CITY OF ALBUQUERQUE

November 21, 2014

**Re: Chili's at Gibson and University
Drainage Report and Grading Plan and Drainage Plan
Engineer's Stamp Date 11-6-14 (M15D012B)**

RONALD R. BOHANNAN P.E. #7868	CHILI'S UNIVERSITY BLVD & GIBSON BLVD	DRAWN BY DY
	GRADING AND DRAINAGE PLAN	DATE 12/30/14
 TIERRA WEST, LLC 5571 MIDWAY PARK PLACE NE ALBUQUERQUE, NM 87109 (505) 858-3100 www.tierrawestllc.com	SHEET # C3	JOB # 2013086
	2013086-CRE

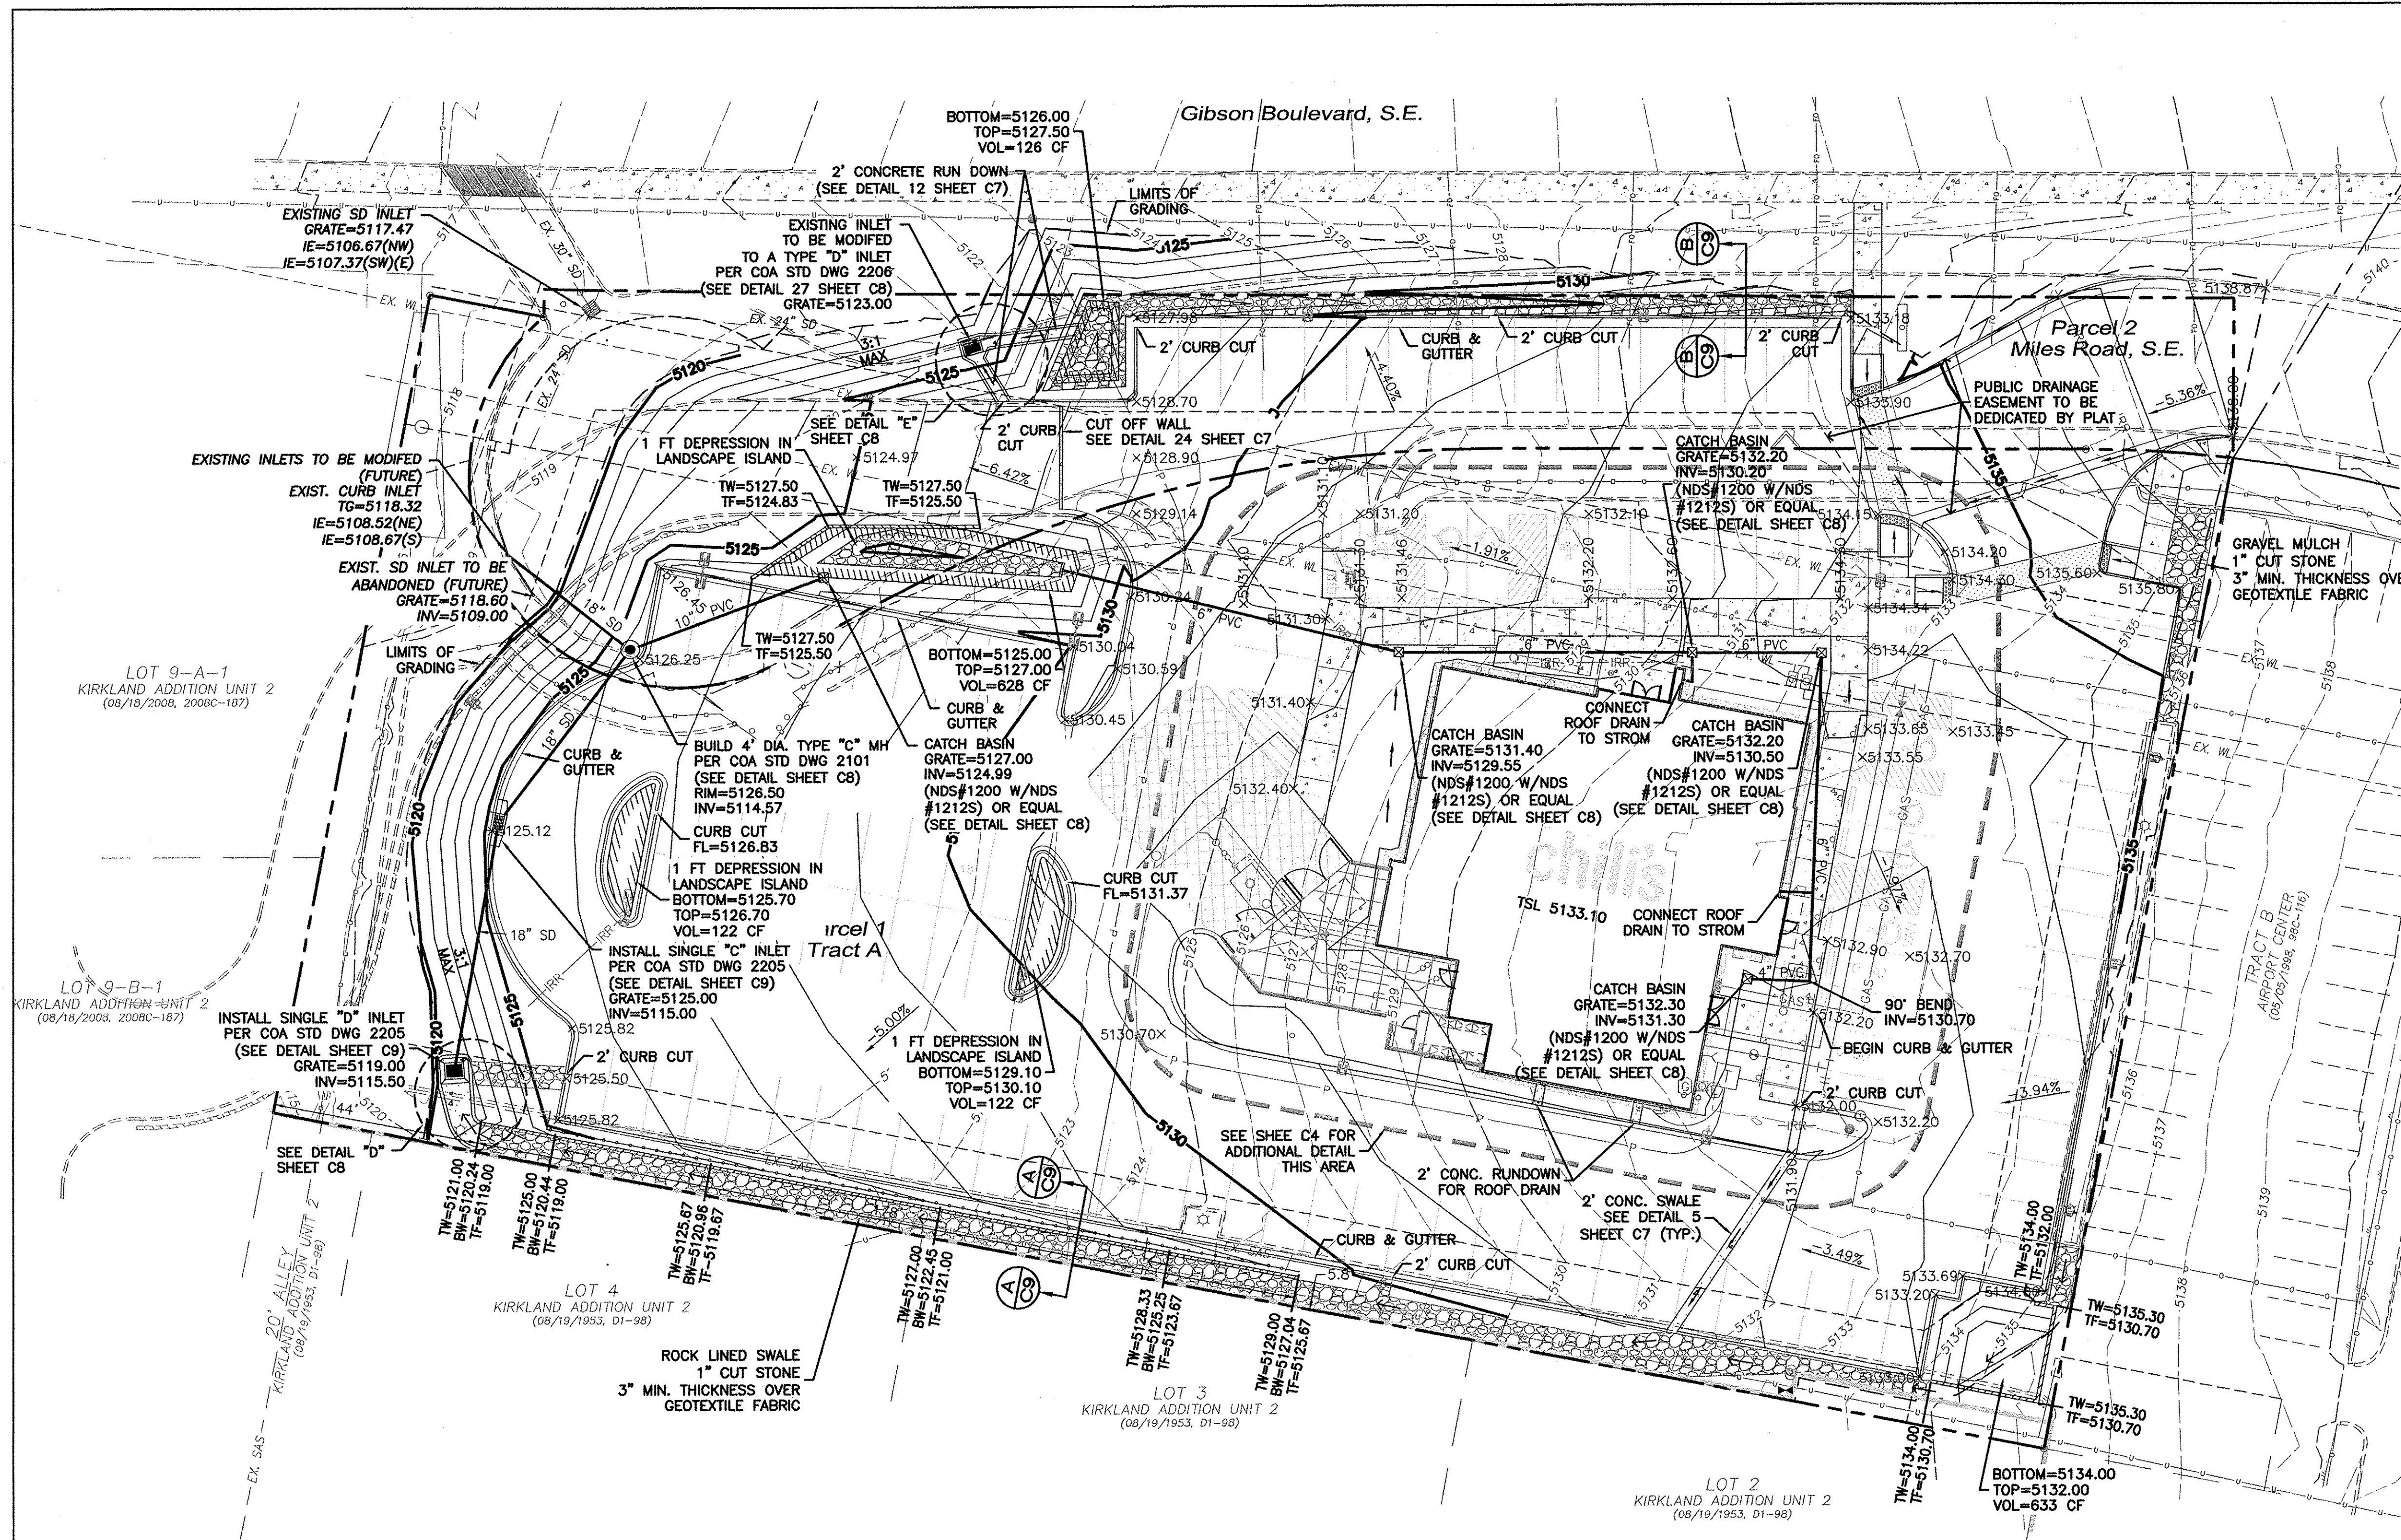
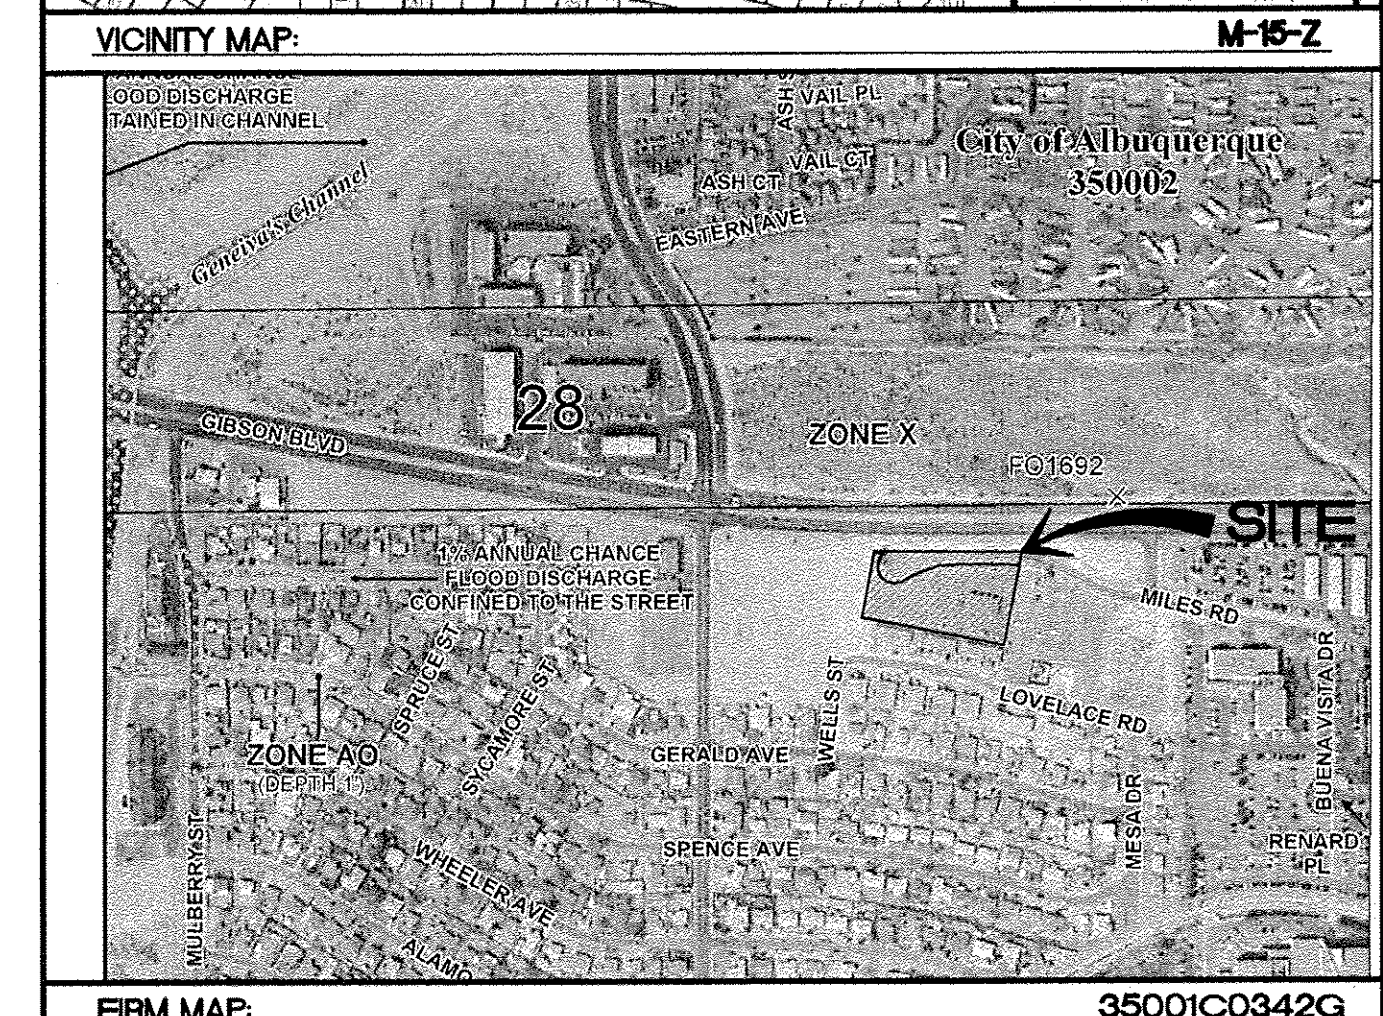
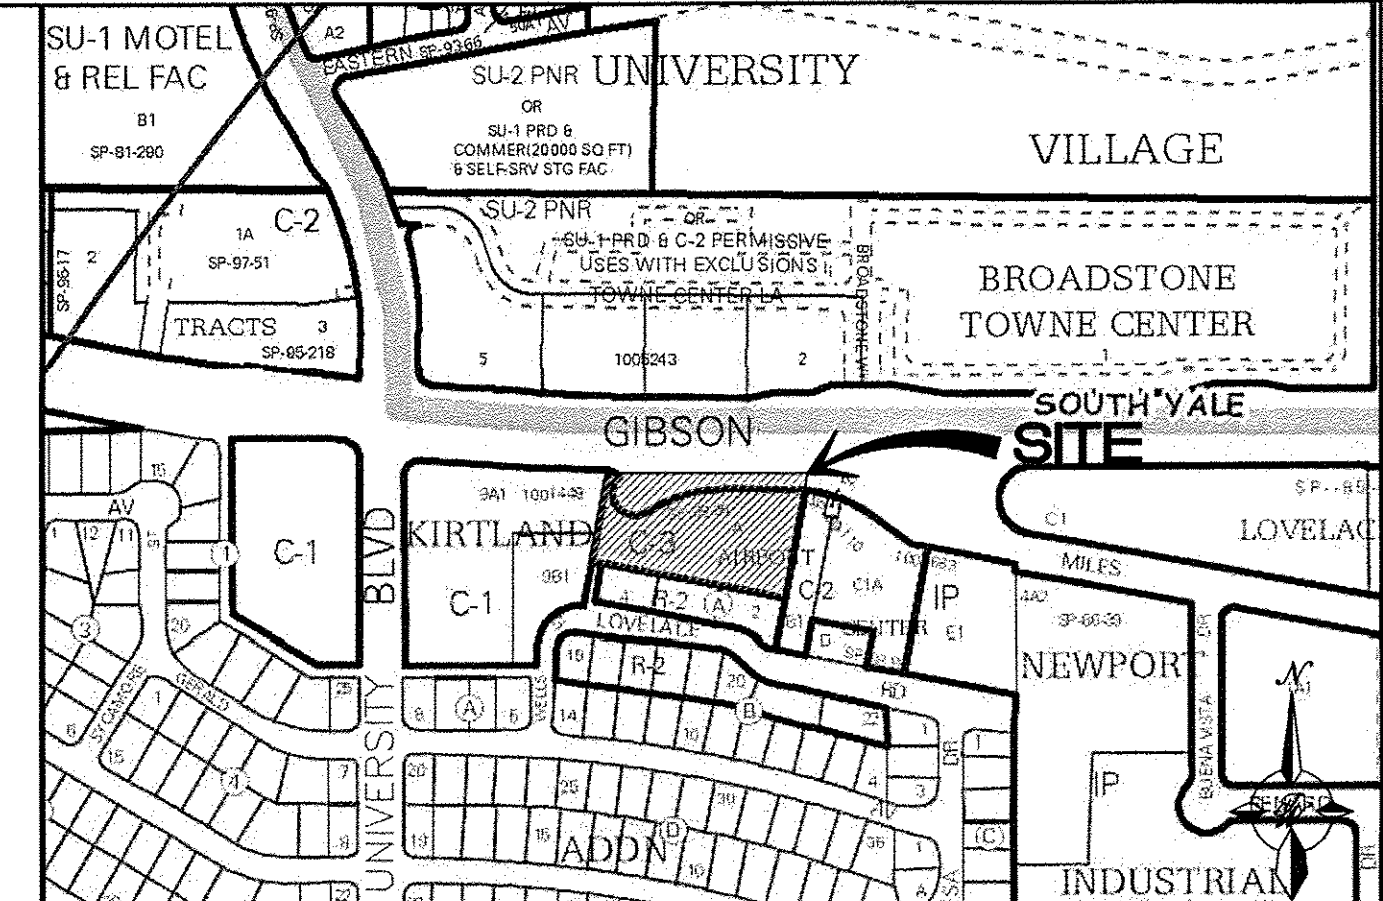
1. The storm water in Miles Road to the east of the site is public water. Public water should not be allowed to drain onto a private site. Capture the storm water from Miles Road before the storm water enters the site.

2. The flows stated for the analysis points 2 and 3 and flows identified in the 18 inch storm drains do not seem to correspond to the basins draining to them. How were those determined? Provide an analysis point for the flow going to Gibson.

3. Existing contours on the west side of the property are not completely visible. Show those. Provide the grate and inlet elevations of the existing inlet connected to the 30 inch storm drain.

- A. Depress islands as much as possible. Provide curb cuts with elevations and bottom elevations.
 - B. Make the southern swale a detention/retention pond with the restricted outlet or raise the outlet above the bottom elevation to create some retention. Where an inlet is being proposed with a grate elevation 5126.90, shorten the rundowns, create a ponding area, and raise the inlet above the bottom of the pond.

- C. Where an inlet is being proposed with a grate elevation 5123.00, create a ponding area and raise the inlet above the bottom of the pond.

- There are many locations to allow water to percolate. Utilize as many as possible.
6. Move the southwestern inlet west without going into the future driveway to capture more flows from the steep slope and to keep as much flow as possible from going to the site to the west.

SECTION A-A

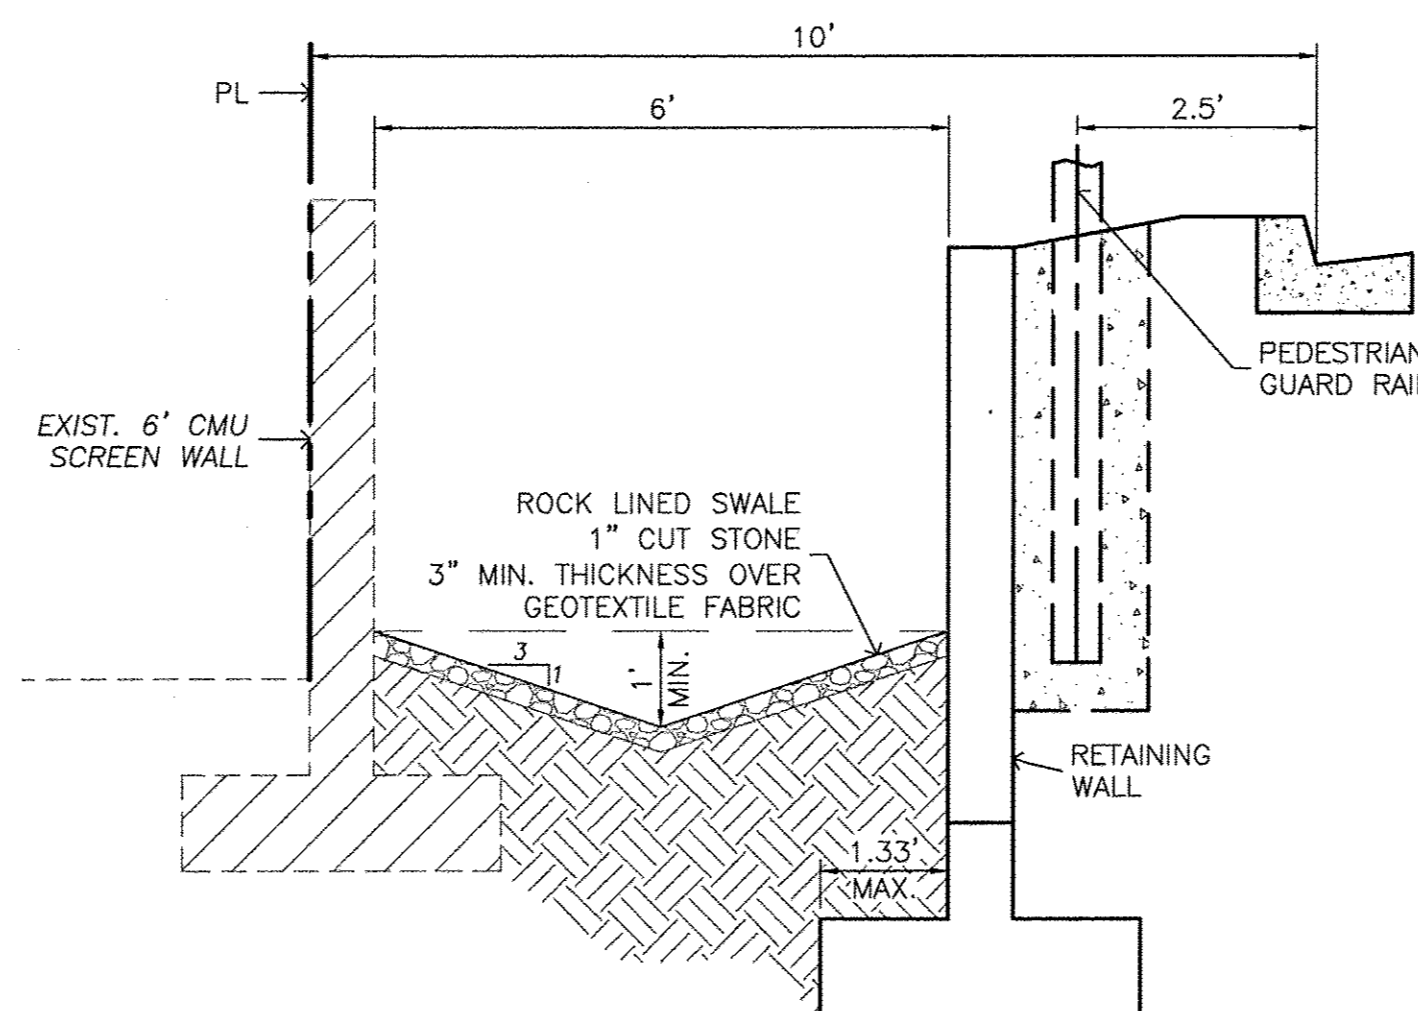
4. How deep is the swale shown in Section A-A on sheet C9? On sheet C3, reference the Concrete Swale detail on C7. Is the Valley Gutter detail needed also? Where does the cut-off wall on sheet C7 go on sheet C3?
